WEST SUSSEX COUNTY COUNCIL CONSULTATION

TO:	Arun District Council FAO: Amber Willard
FROM:	WSCC – Highway Authority
DATE:	26 August 2025
LOCATION:	Land rear of Waterbury House Ford Road Ford BN18 0BH
SUBJECT:	F/21/24/PL Erection of 4 No supported living units (C3(b)), office block, car parking and associated works. This application is a Departure from the Development Plan, affects the setting of a listed building and is in CIL Zone 3 and is CIL Liable as new dwellings. Response to highway comment.
DATE OF SITE VISIT:	11 July 2025
RECOMMENDATION:	More Information Required

PROJECT	WATERBURY GARDENS - FORD
DESIGNER	ASH
PROPOSED SITE PLAN	
DATE	14/02/24
REF. NO.	00072404
DRAWN/CHANGED BY	SP9
DESIGNER'S SIGNATURE	
REVISION

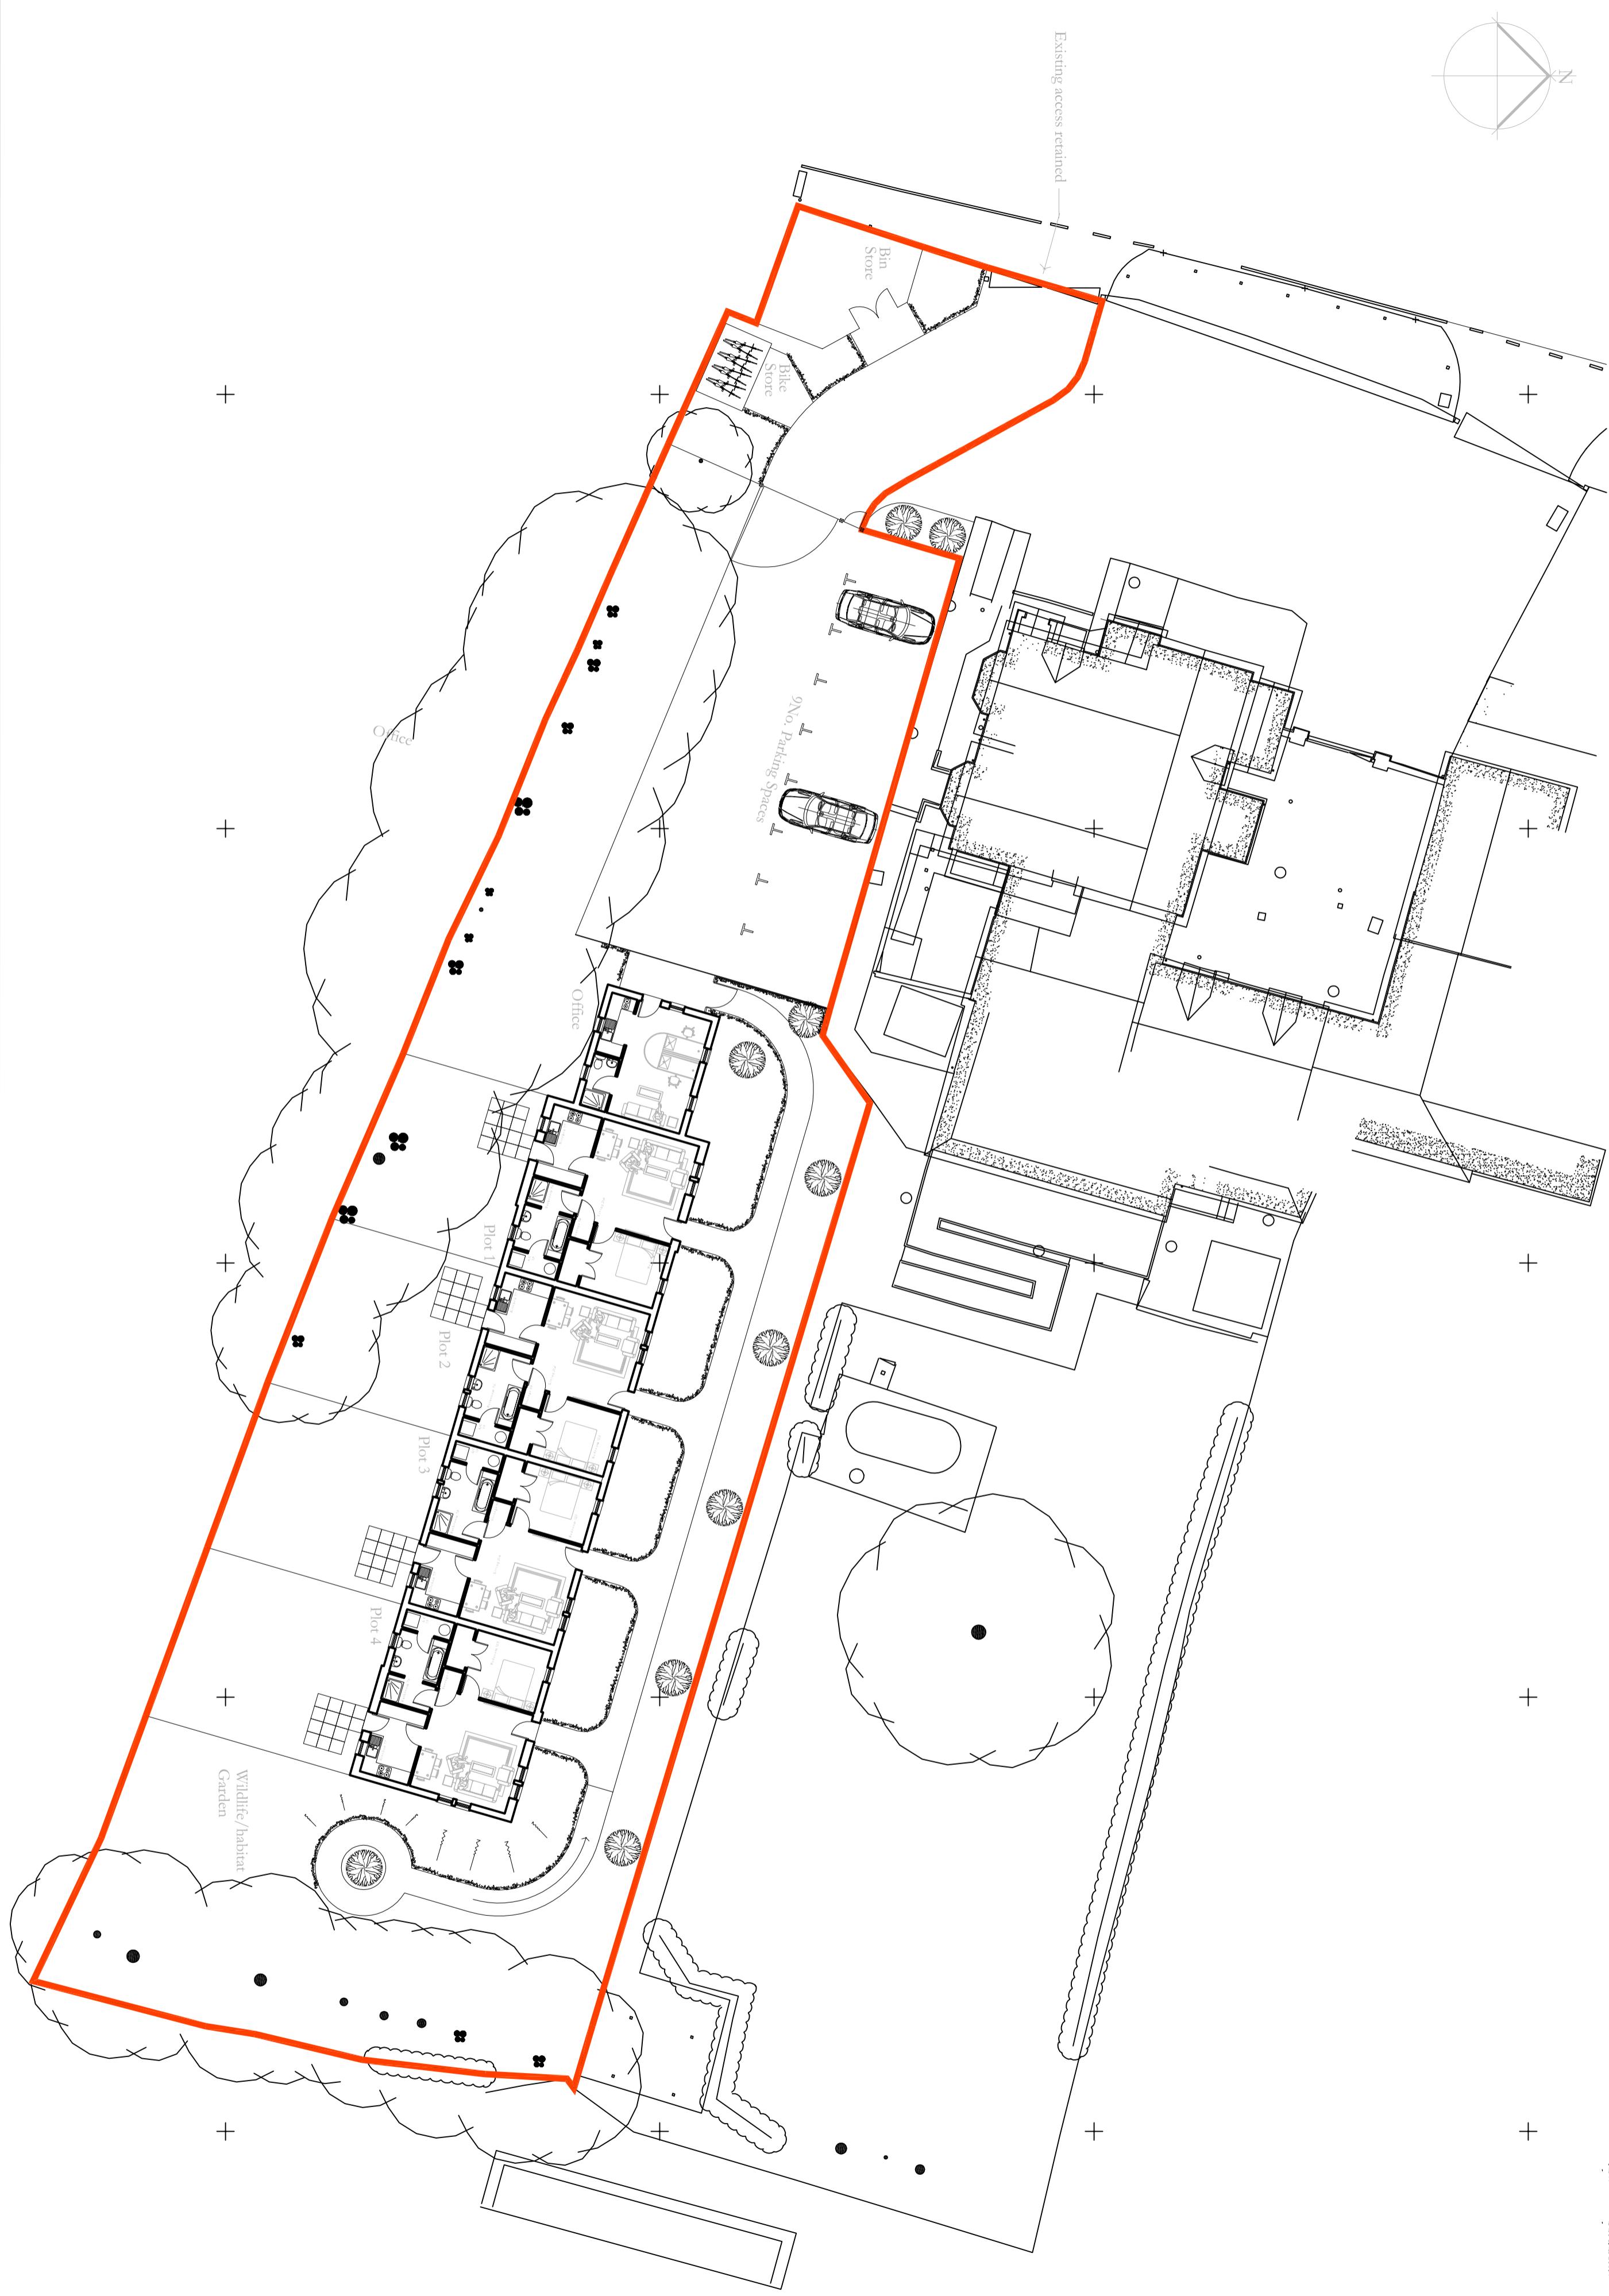
As documented previously, given the close proximity of the southern access to the site to the adjacent railway crossing, the Highway Authority recommended that the southern access to the site be permanently closed to traffic entering and/or leaving the site, as additional vehicles generated by the proposal (particularly those turning right into the site) would be attempting to make that manoeuvre very close to the crossing which could cause obstruction on Ford Road and blocking back over the railway crossing.

From on-site observation, the southern access appears to not be in regular use with cars parked across it within the existing car park. The new proposal, the subject of this planning application, shows this access as the prime access to serve it which could, in operation, be confusing to both new and existing users of the site. The author regularly drives this route and has, since the initial site visit, witnessed the same parking arrangements across the access on several occasions which suggests that the southern access isn't used or not very regularly.

Therefore, contrary to the comment made in the email, the on-site situation and requirements for access would appear to be changing from how the site appears to operate at present.

In the email, the architect doesn't explain what the CQC requirements for access are and why. Furthermore, the applicant doesn't explain how the proposed access arrangements would work based on two accesses being available to the site and alongside the existing operations within the existing building (i.e. old public house building). Existing and proposed traffic flows should also be provided.
